Application PRE22/0191
Ref: (Please quote at all times)
Date: 13th May 2022

**TOWN AND COUNTRY PLANNING ACTS 1990 (AS AMENDED)
YOUR PRE-APPLICATION ENQUIRY**

APPLICATION NO: PRE22/0191
DESCRIPTION OF DEVELOPMENT: Erection of a rear extension and extension of residential curtilage.
APPLICANT: Mr Christopher Green
LOCATION: 61 And 61A Siston Common Siston South Gloucestershire BS15 4PA

DWG NO CC/09

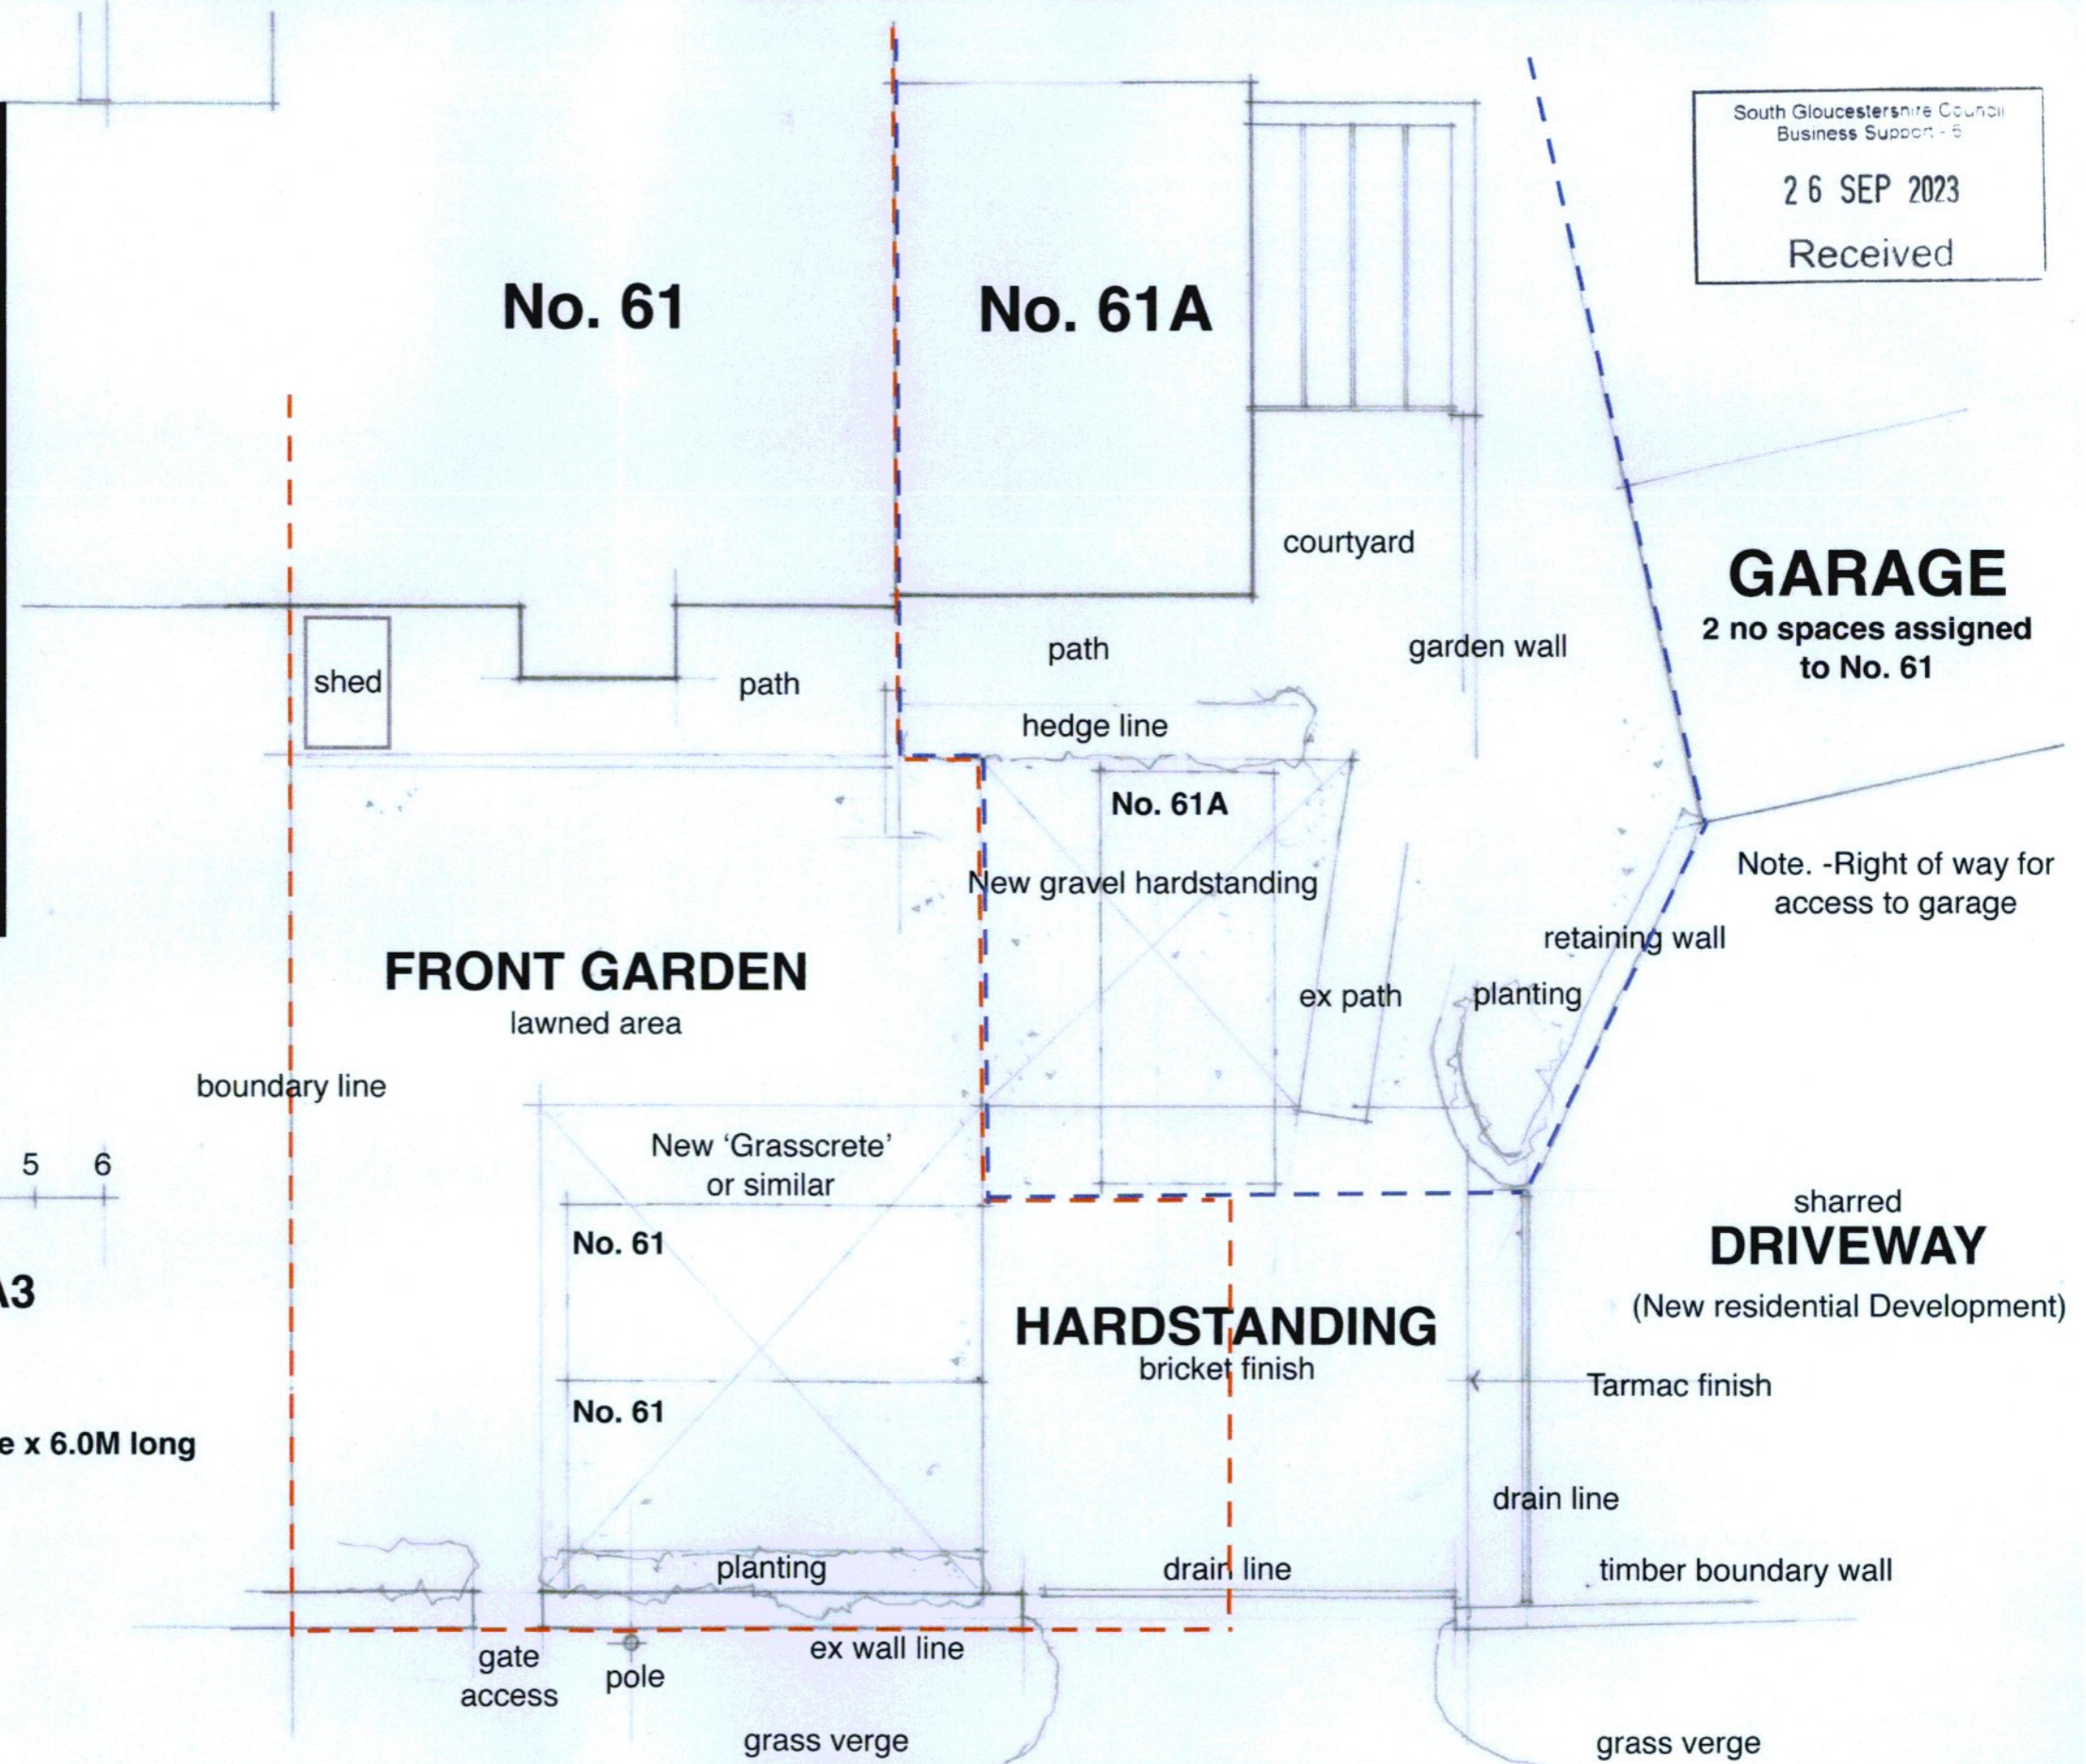
The application supporting statement suggests that the dwelling as extended would have five bedrooms. This means 3no. parking spaces are required to accord with PSP16 (parking standards). There appears to be enough space within the curtilage to the front of the property to provide the necessary parking. This however should be clearly articulated on the site plan submitted with any forthcoming planning application.

REAR ELEVATION

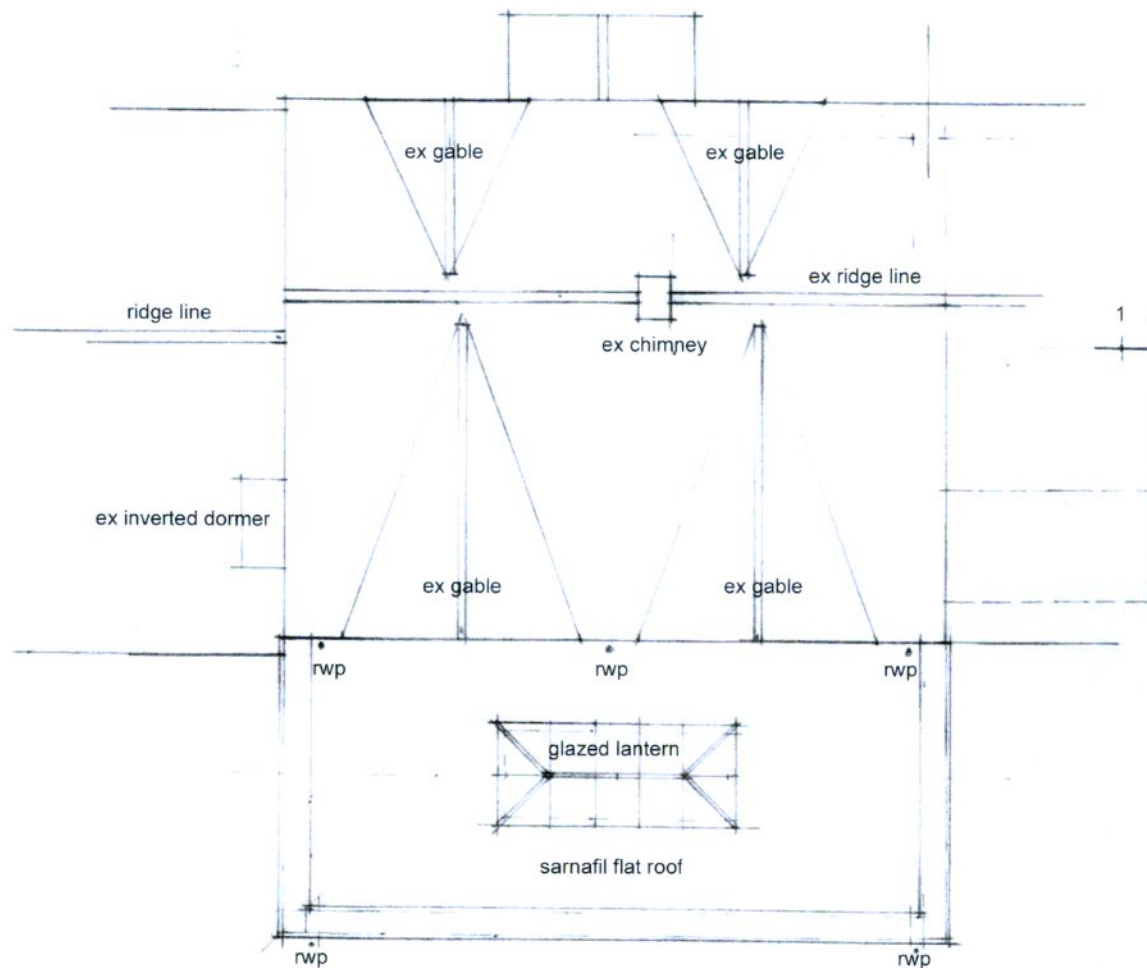
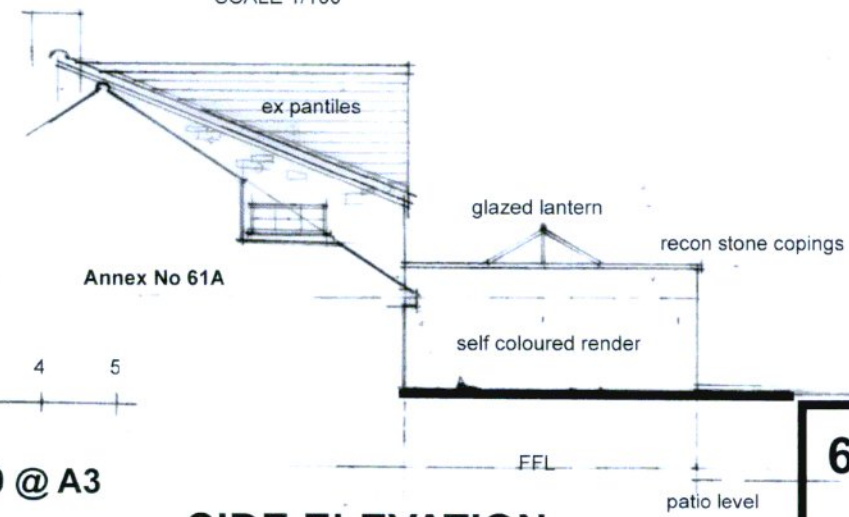
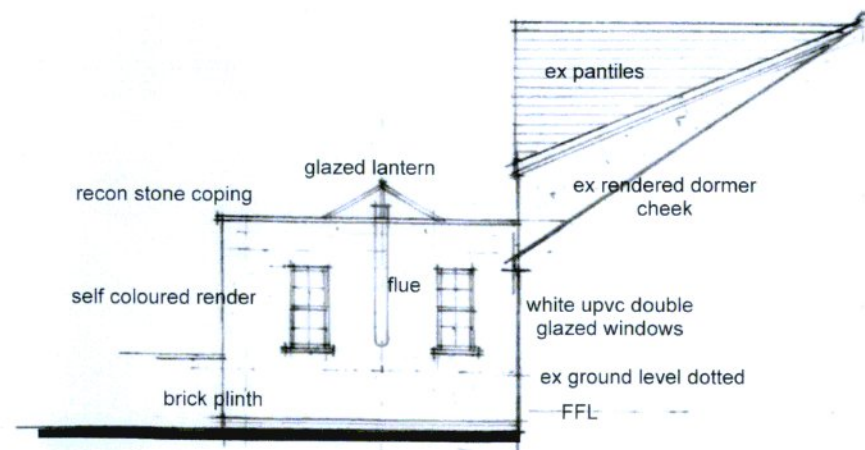
No elevations have been provided for the extension; however, this would need to accord with the requirements of the above noted policies (CS1, PSP38 and the Householder Design Guide SPD). As no elevations have been provided then no detailed design advice can be provided at this stage, however it would be unlikely that a suitably designed rear two storey extension would be resisted in principle in this location.

A rear extension would be likely to be possible without having any unacceptable amenity impacts, subject to the scale, relationship to the neighbouring dwellings (particularly the attached dwelling to the West), placement of openings and compliance with the tests set out in the residential amenity section of the Household Design Guide SPD (Adopted) March 2021.

**SECTION AS
PROPOSED**

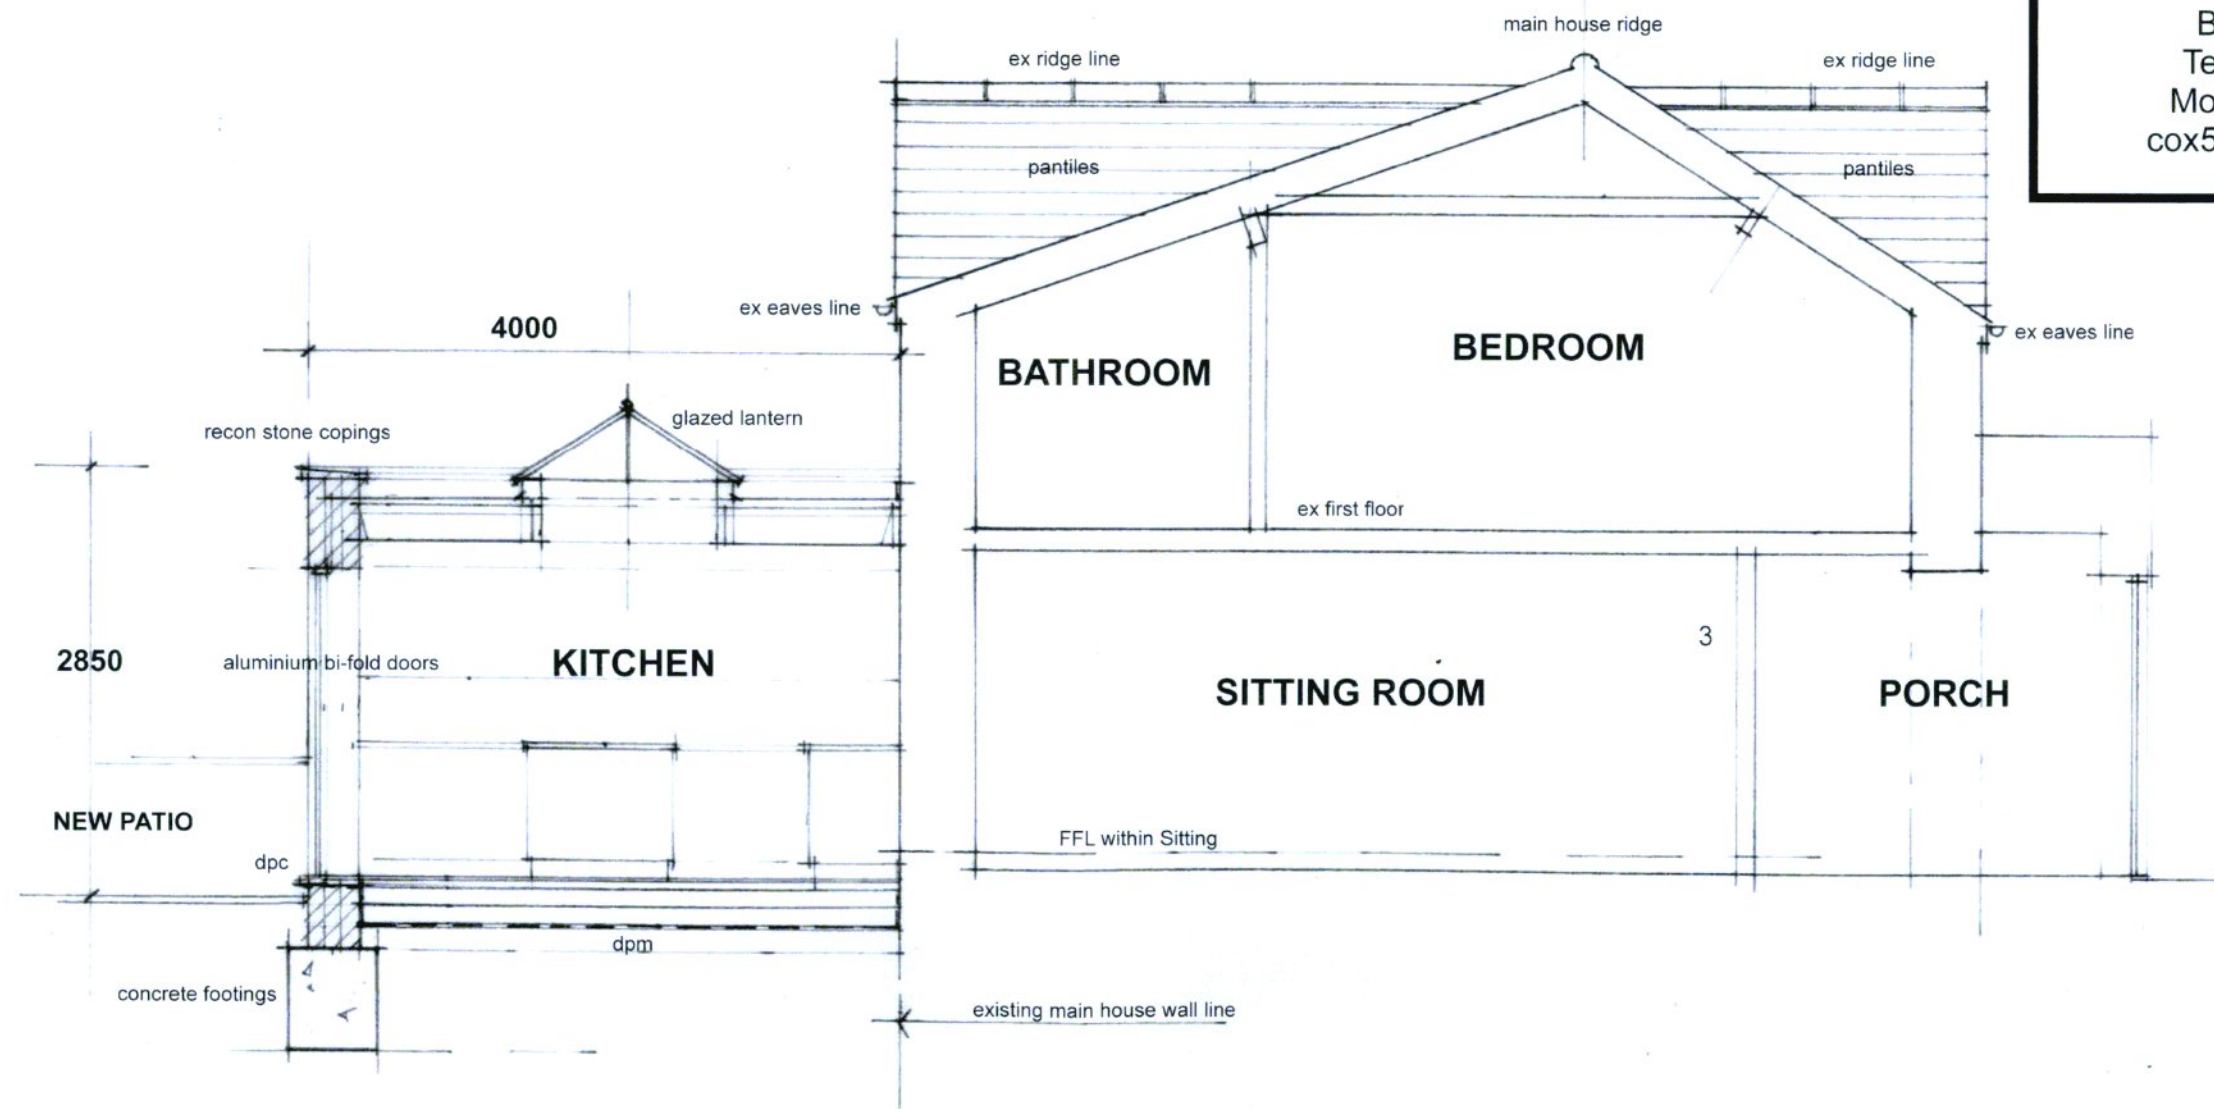
The proposed curtilage extension is noted above to be acceptable in principle. In terms of its visual impact, it is noted that the field sits at a higher level towards the rear of the property and so it would be assumed that some re-profiling would be required coupled with the necessary retaining structure to enclose the new curtilage. This would differ somewhat to the development to the East where it appears that the extended parts of the gardens are at a higher level (i.e., the gardens are terraced). There would be unlikely to be any fundamental visual and landscape concerns with the need to create retaining structures, however this would be subject to a satisfactory design which should be clearly communicated as part of any full planning application. It would be recommended that the services and advice of a landscape architect are sought with regards to the design and landscaping to the rear, and any full application would be expected to be supplied with landscaping details to ensure that the development into the field does not appear unduly urban and respects the character of the area. It would also be expected that appropriate section drawings are provided to demonstrate the design of the retaining structures, and how they will relate to neighbouring properties.

In addition to the usual full scaled plans and elevations, any full application should be supplied with ecological information as outlined above, to be prepared by a suitably qualified person. With regards to the curtilage extension, plans should be appropriately detailed in terms of levels and retaining structures and should include section drawings to allow a full and informed assessment.
